Application no: H11-0260-11

Description: Proposed extensions to dwelling

Location: 23 Station Road
Long Sutton
Spalding
Lincs
PE12 9BP
PE12 9BP

Amendment: Addition of window (dwg. no. WEN/1420/11/01)

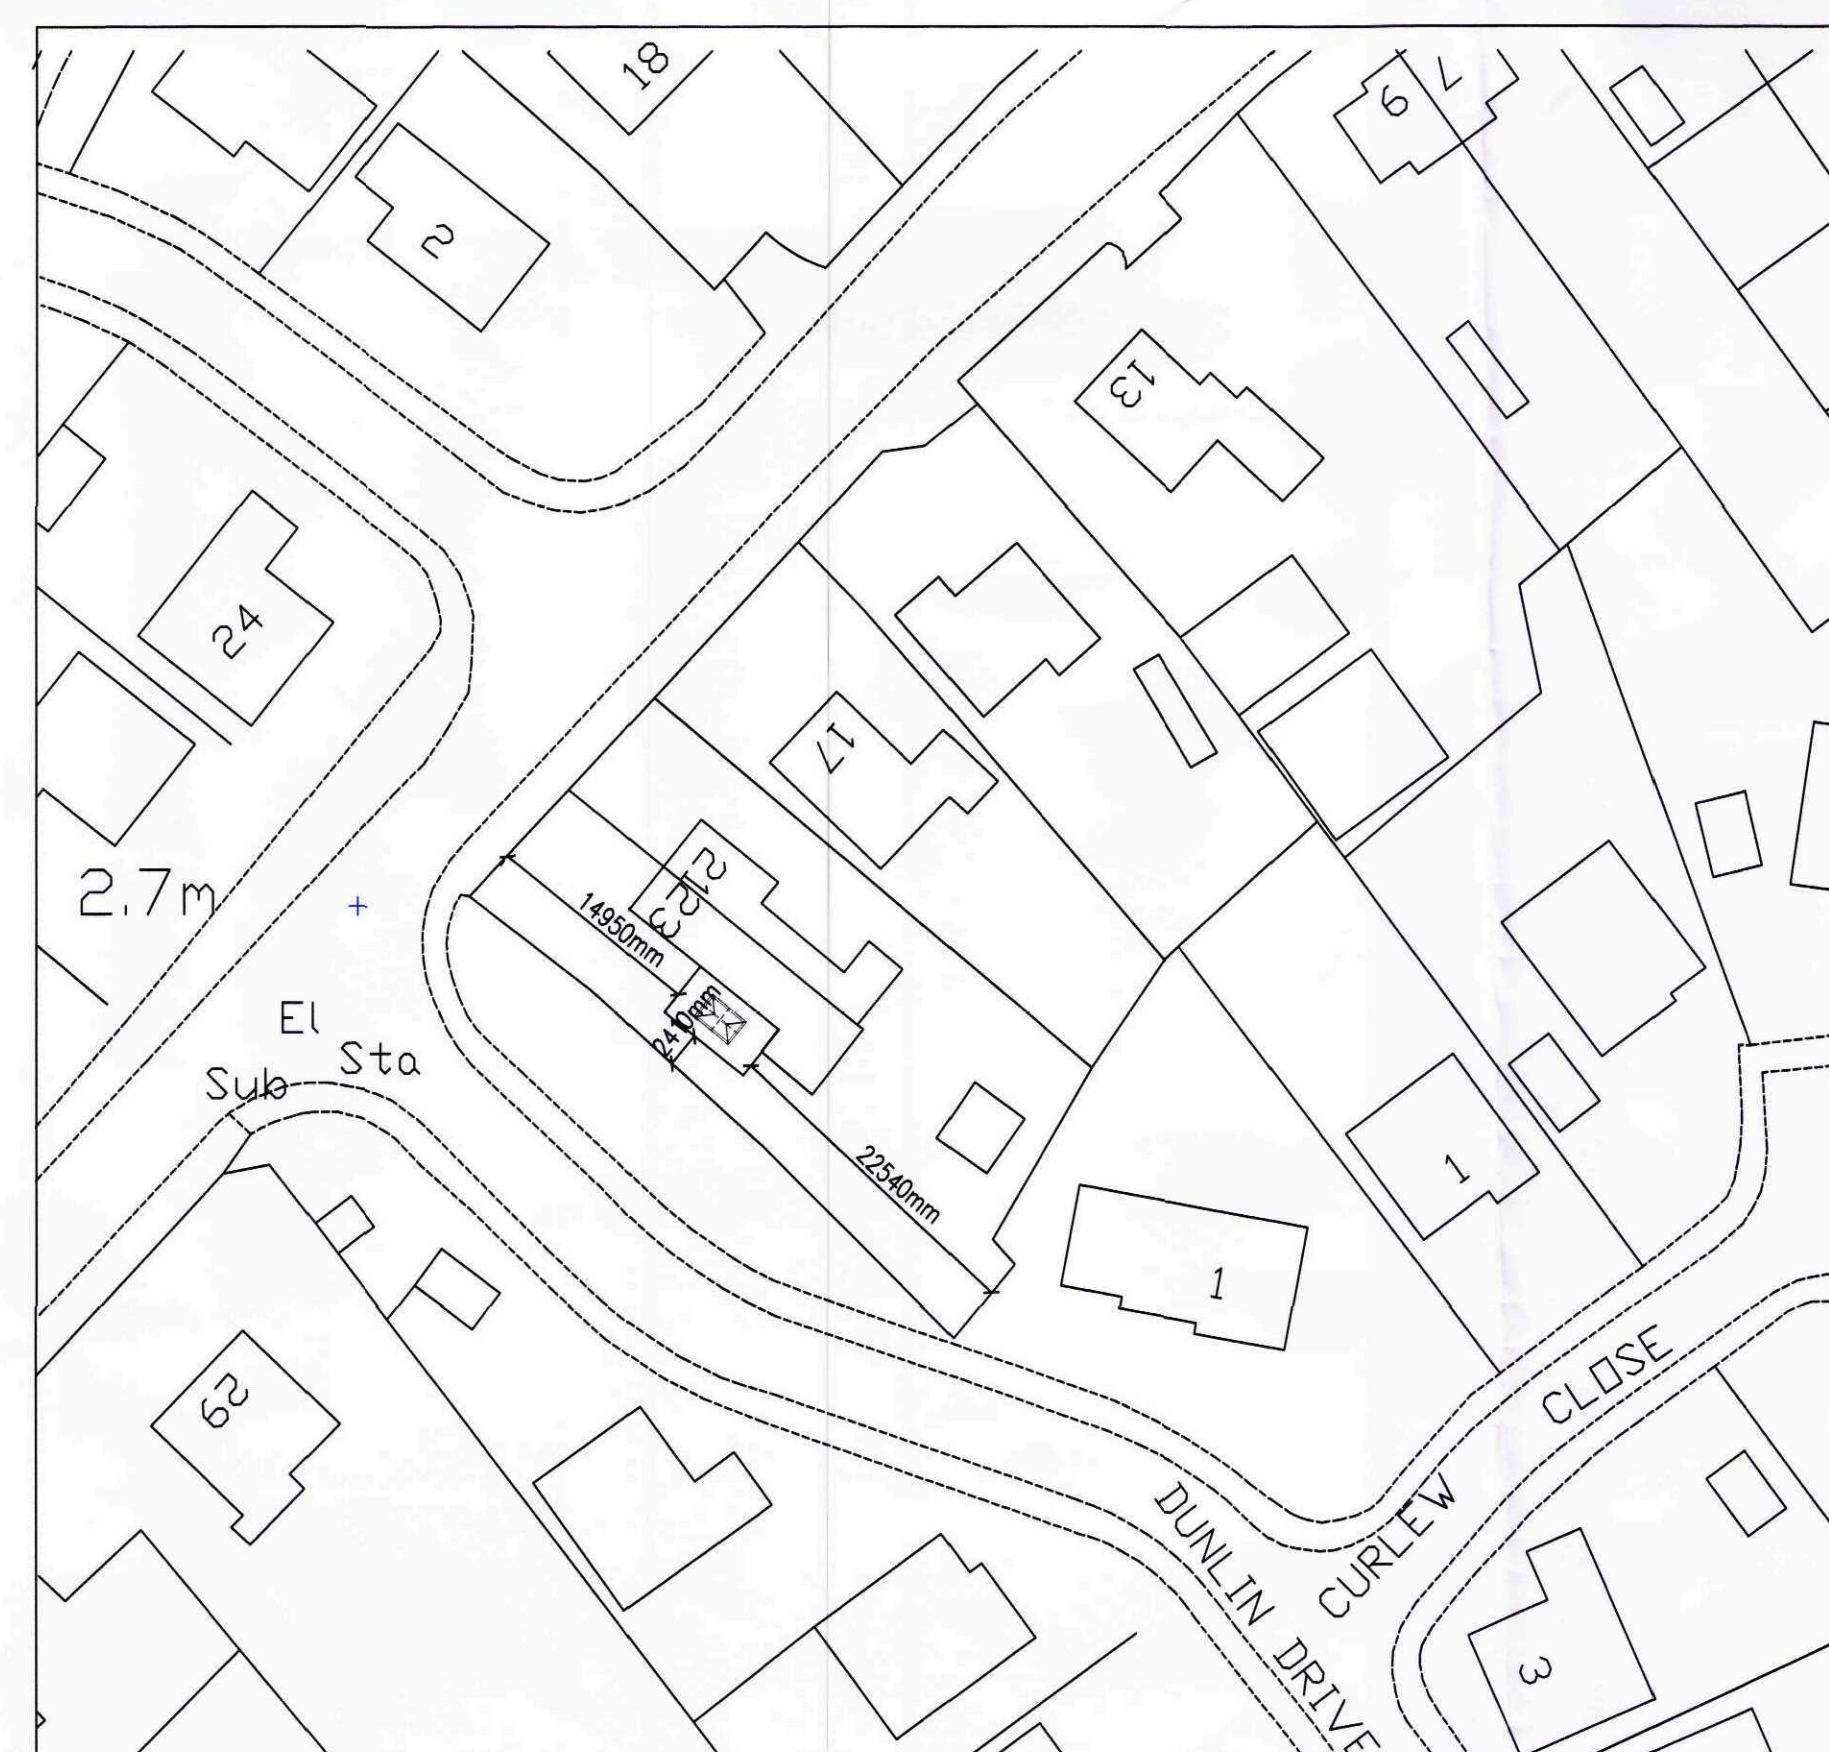
Whilst no objections are raised in principle to a window in this location it is considered that all new windows on this elevation (including associated arches) should reflect the Georgian design of the windows on the front elevation and not be arched.

Please find an amended plan showing a square window as suggested.
